**Re: Grading and Landscaping Planning,
Proposed Building Addition
100 Terence Matthews Crescent
Ottawa, Ontario**

As requested, this letter provides a grading plan review for the proposed building addition to be located at 100 Terence Matthews Crescent in the City of Ottawa, Ontario.

- Drawing No. C101, prepared by McIntosh Perry titled "Site Grading, Drainage, Erosion and Sediment Control Plan", Revision Number 1, dated October 7, 2022; and,
- Drawing No. L1, prepared by GJA Inc. titled "Landscape Plan", Revision Number 3, dated January 6, 2023.

Drawing Title: **SITE GRADING, DRAINAGE, EROSION AND SEDIMENT CONTROL PLAN**

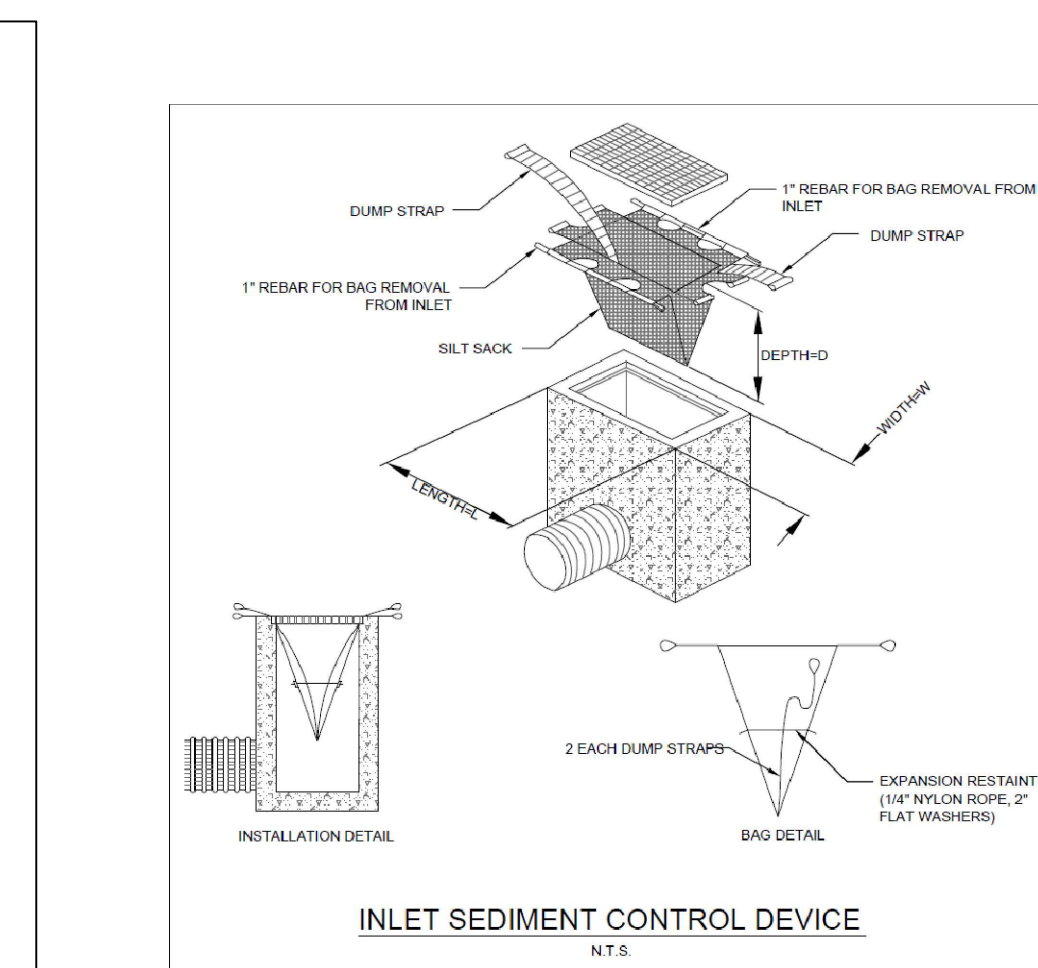
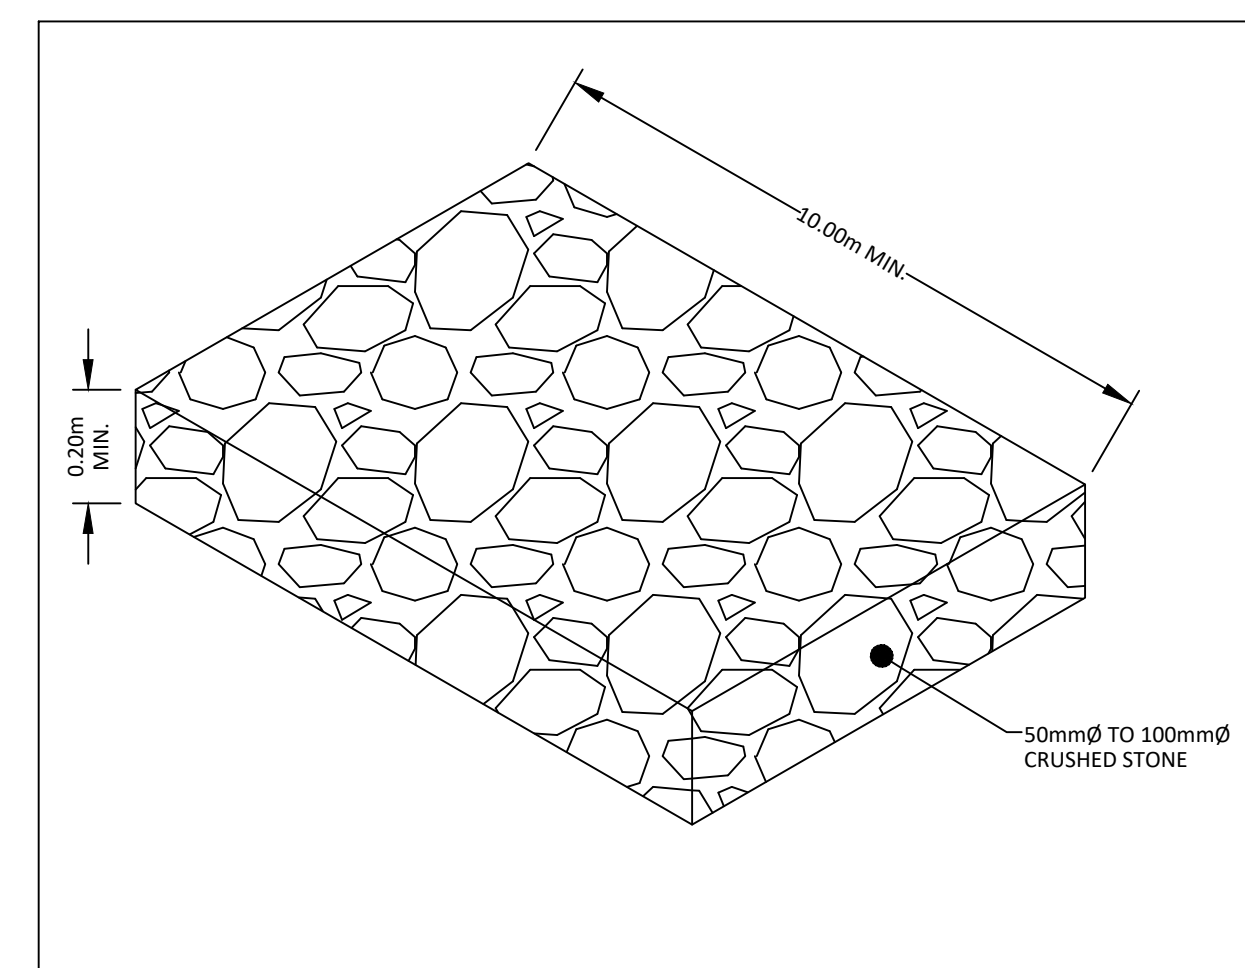
GEMTEC has reviewed the plan titled 'Site Grading, Drainage, Erosion and Sediment Control Plan', in terms of the proposed grade raise fill that will be imported to the site for grading purposes. The intention of the review is to assess the potential for settlement of structures which could occur due to the proposed elevation of grade raise filling above existing ground surface.

Based on the results of our previous investigation, the maximum thickness of any grade raise filling should be limited to at most 0.6 metres above original ground surface (i.e., the surface of the native soil, which is below the existing grade). The moist unit weight of the fill material that is used in the vicinity of the structures should be less than 20 kilonewtons per cubic metre after placement and compaction.

Based on a review of the above mentioned drawings, the final finished grades are generally below the maximum allowable, with the exception of the southeast corner of the proposed addition, which has a proposed grade raise of 0.61 metres. This is considered acceptable from a geotechnical point of view since the grade raise exceedance is minor (i.e., 0.01 metres).

The proposed addition is provided with 1.49 metres of earth cover for frost protection. This is less than the minimum requirement of earth cover for frost protection (1.50 metres), however, this is considered acceptable from a geotechnical point of view.
